One Earth Solar Farm

**Draft Statement of Common Ground with Nottinghamshire
County Council**

EN010159/APP/8.3.1

July-August 2025

- Site outline
- 2km radius
- 1km radius
- Unregistered Park & Garden
- Non-designated heritage asset

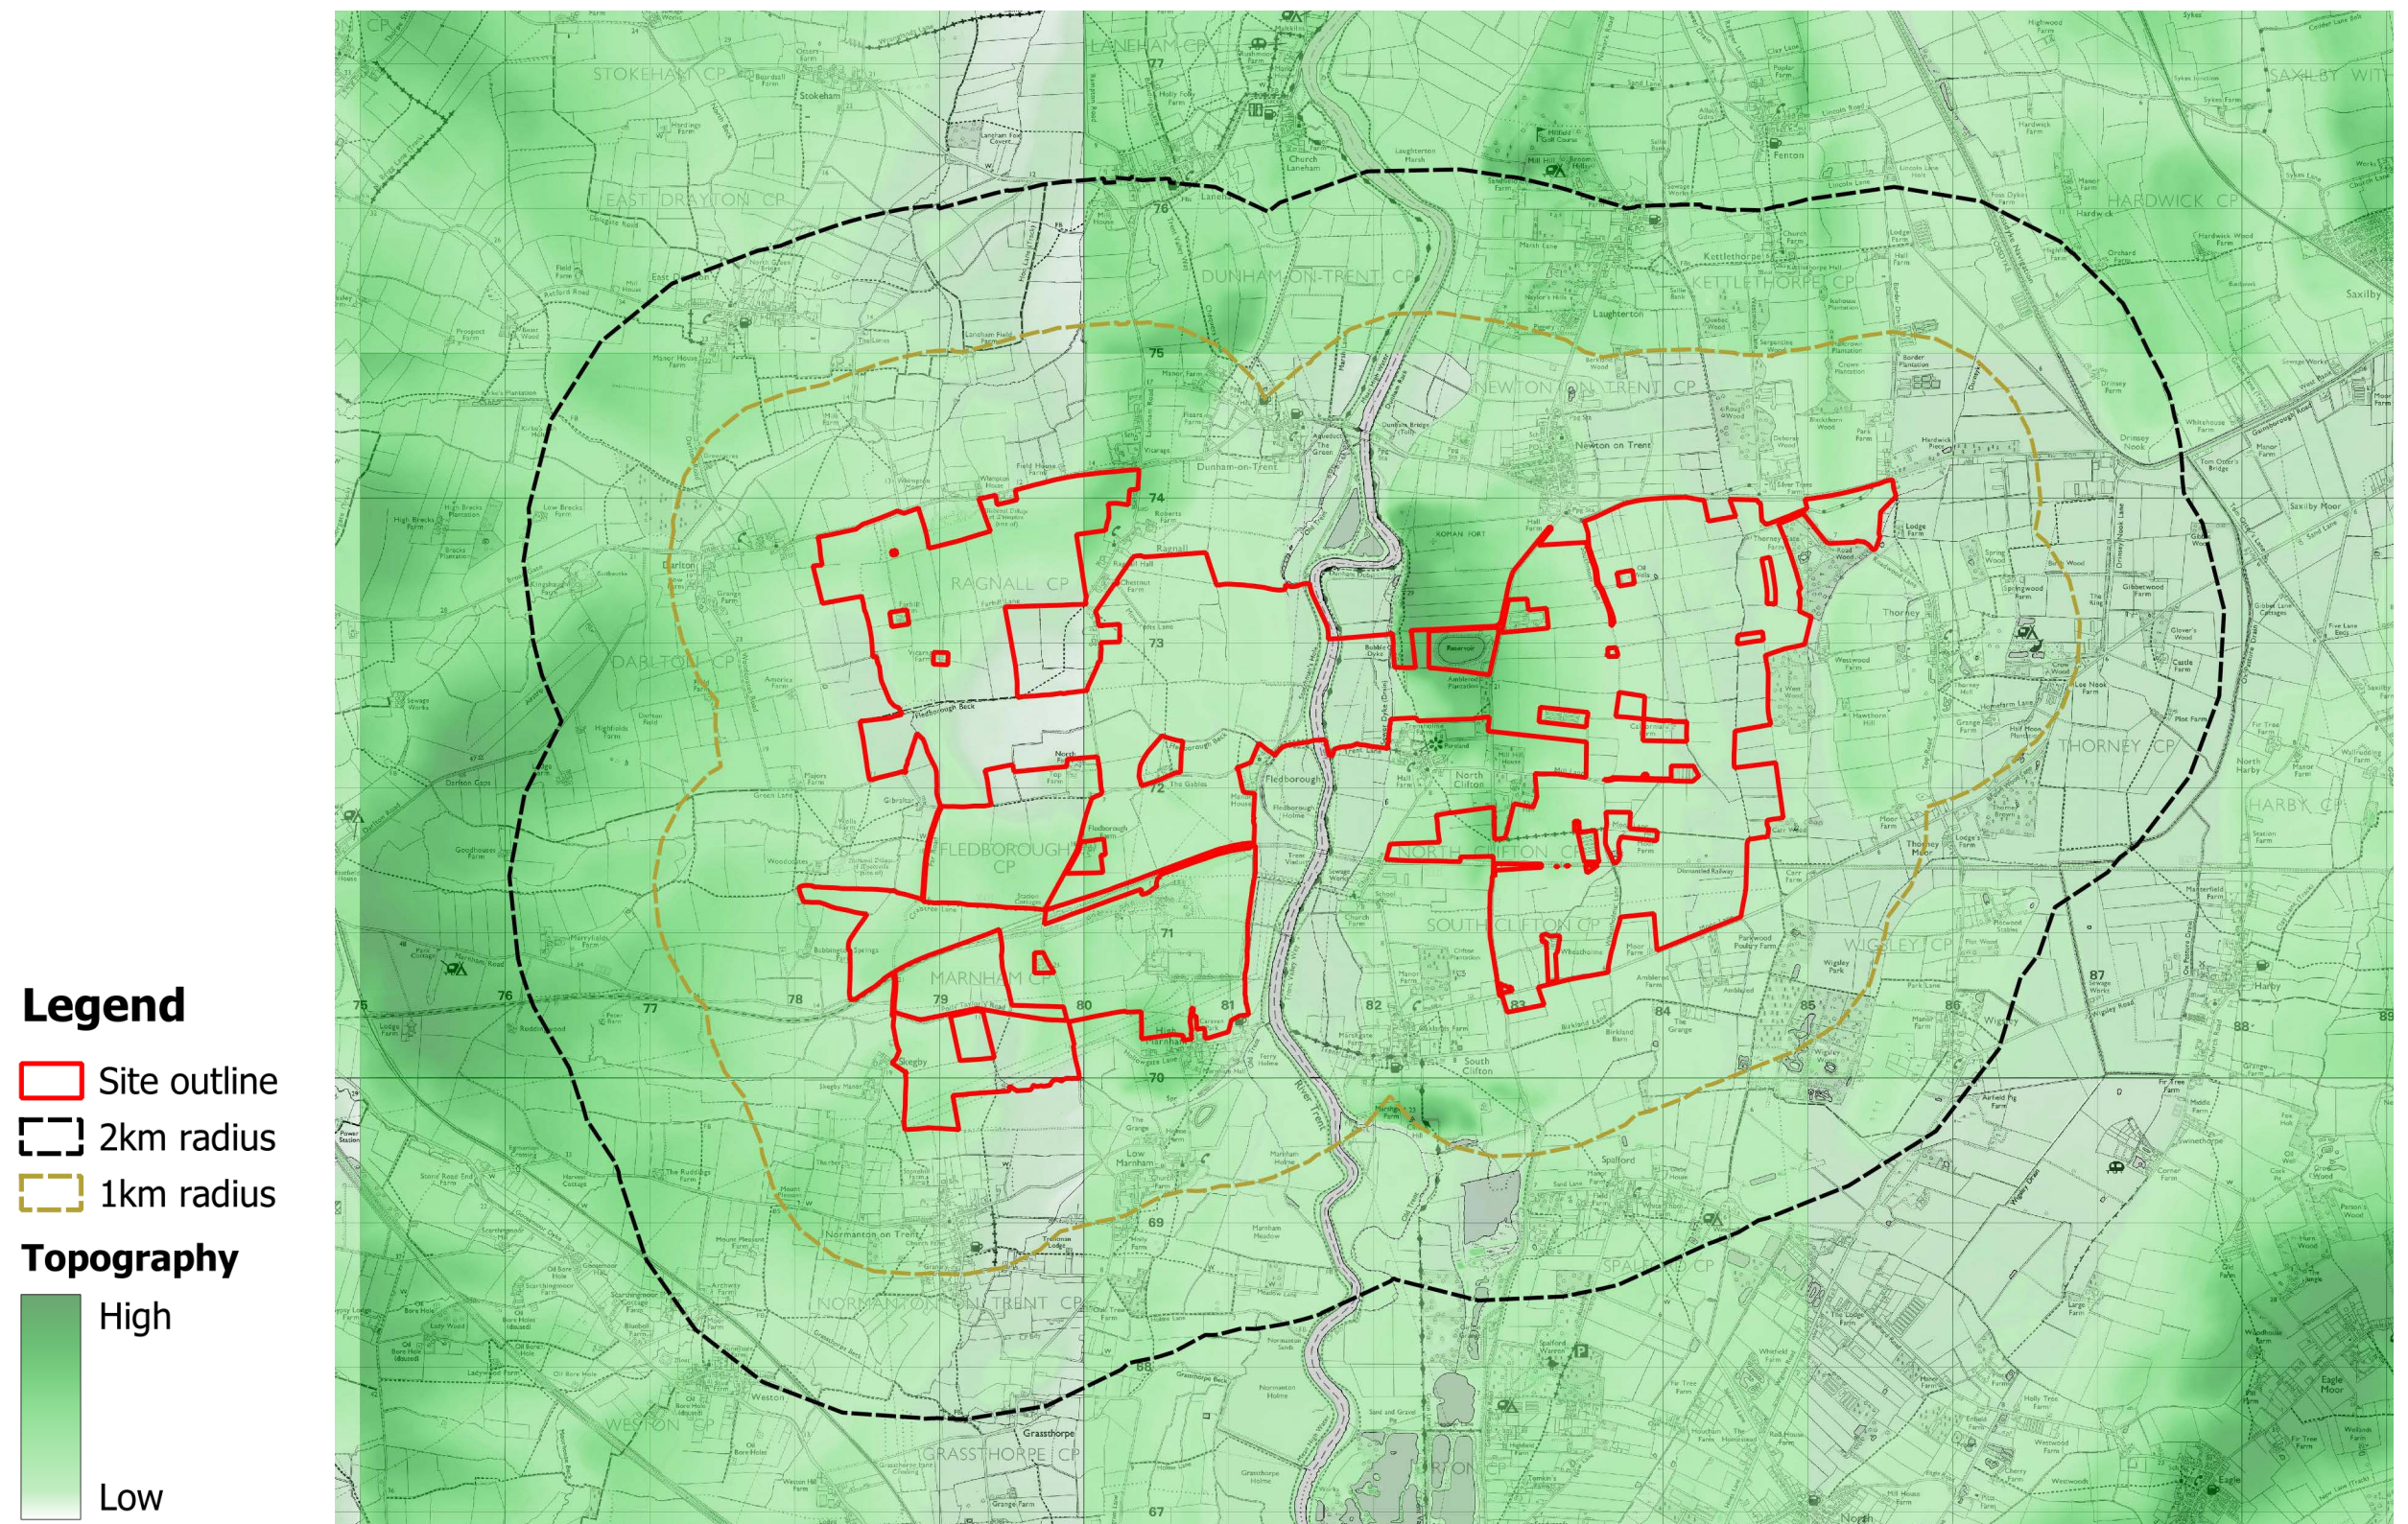
Discussion and agreement to review how the development relates to contouring to the north and northwest of St Leonards Church. It was agreed that topography would be overlayed onto the masterplan to demonstrate the relationship between the two.

Outcome: Order Limits are shown with topography overlay on page 8 of Technical Appendix 10.2 (APP-127). Discussion held on creating set backs to the east of Main Street and
